Our ref: NO/2023/115662/02-L02
Your ref: 3/2023/0754
Date: 18 January 2024

**PROPOSED CHANGE OF USE OF AGRICULTURAL LAND TO NEW CAR PARK
AND STORAGE YARD.
JUDGE WALMSLEY MILL, LONGWORTH ROAD, BILLINGTON, BB7 9TP**

Environment Agency position

dwg purpose  
Proposed Car Park

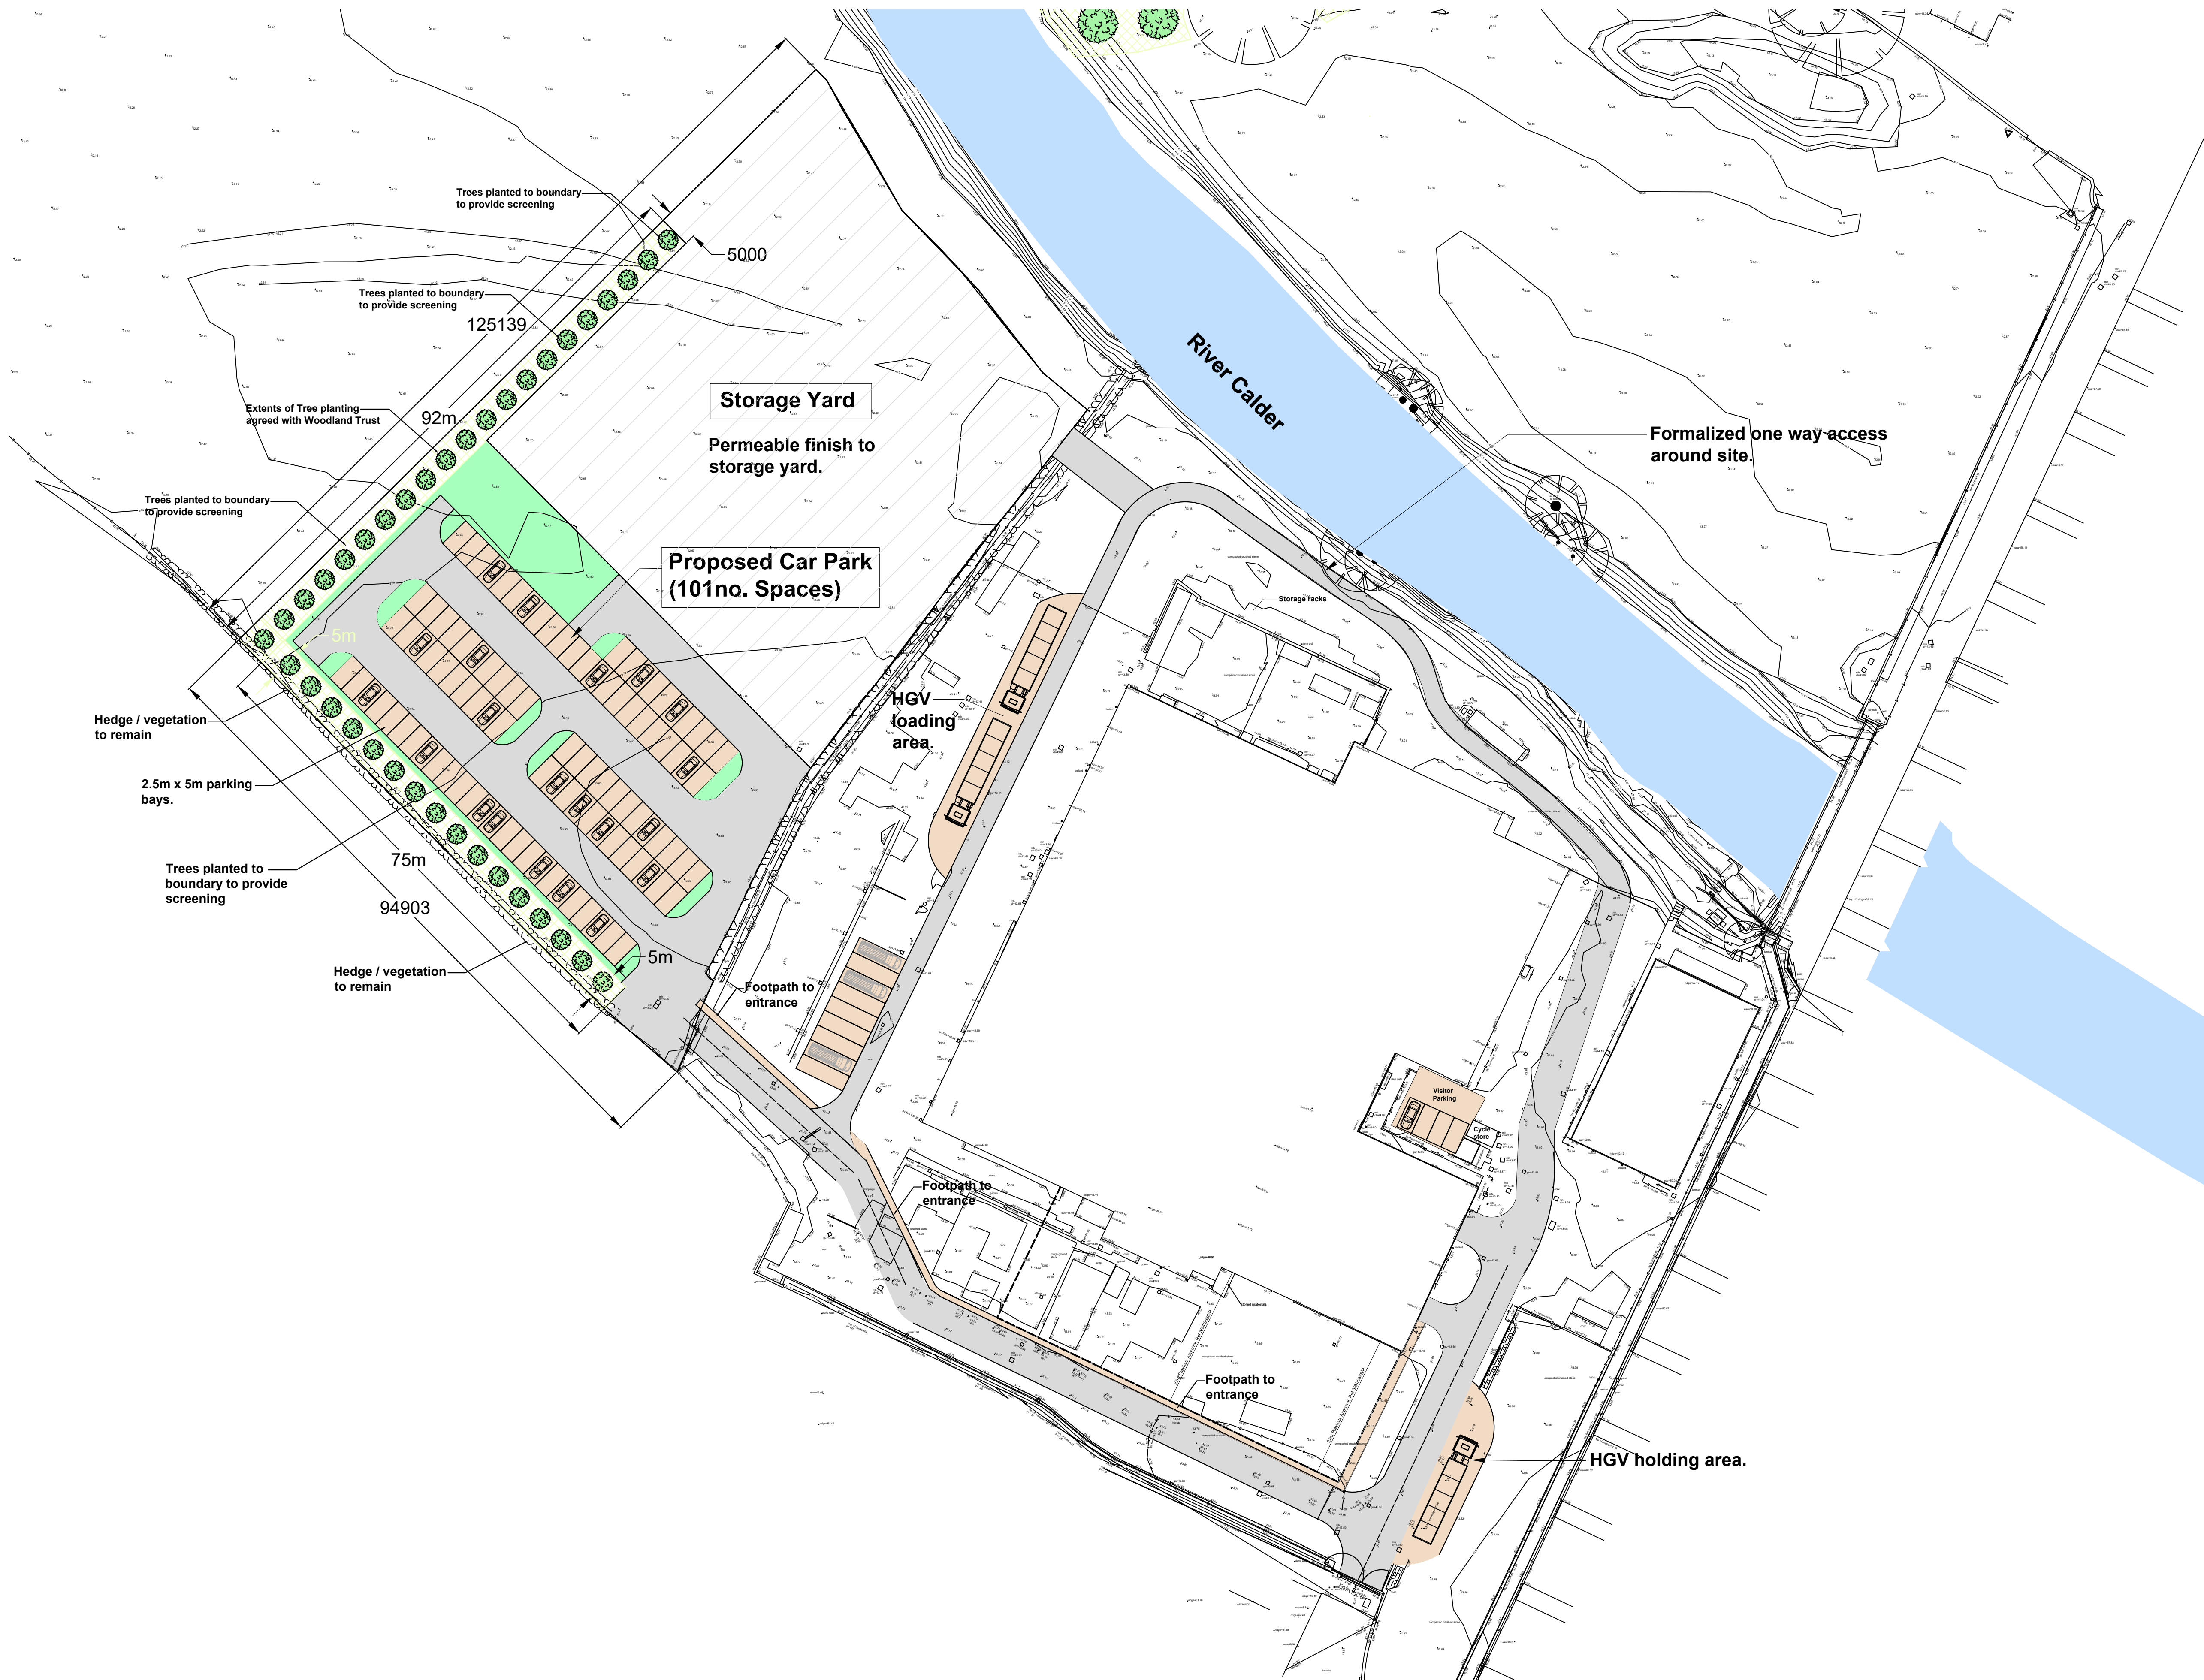
For avoidance of doubt, in relation to points 1 and 2 of our letter ref: NO/2023/115662/01-L01, please revise the FRA to include information and to support the statement that there will be no alteration of ground levels.

- Provide details in the form description within the FRA, together with topographic plans and sections clearly showing the existing and proposed grounds levels (in mAOD), together with plans and sections showing the construction details, materials specification, and any external works details in the form of kerbing and edge restraints for the proposed new car park and storage yard.

In relation to point 3, while we accept that not raising ground levels and increasing the permeability of the surface should not be detrimental to flood risk, no evidence is provided to support the statement of flood risk betterment, or consideration of not increasing flood risk elsewhere, as requested.

- The development proposes change of use from agricultural to a proposed new car park and storage yard to facilitate the storage of large, manufactured products and materials. The FRA should provide evidence to support the statements made. This should include information about maintained flow routes and connectivity to the wider flood plain in the modelled flood event and design flood event.
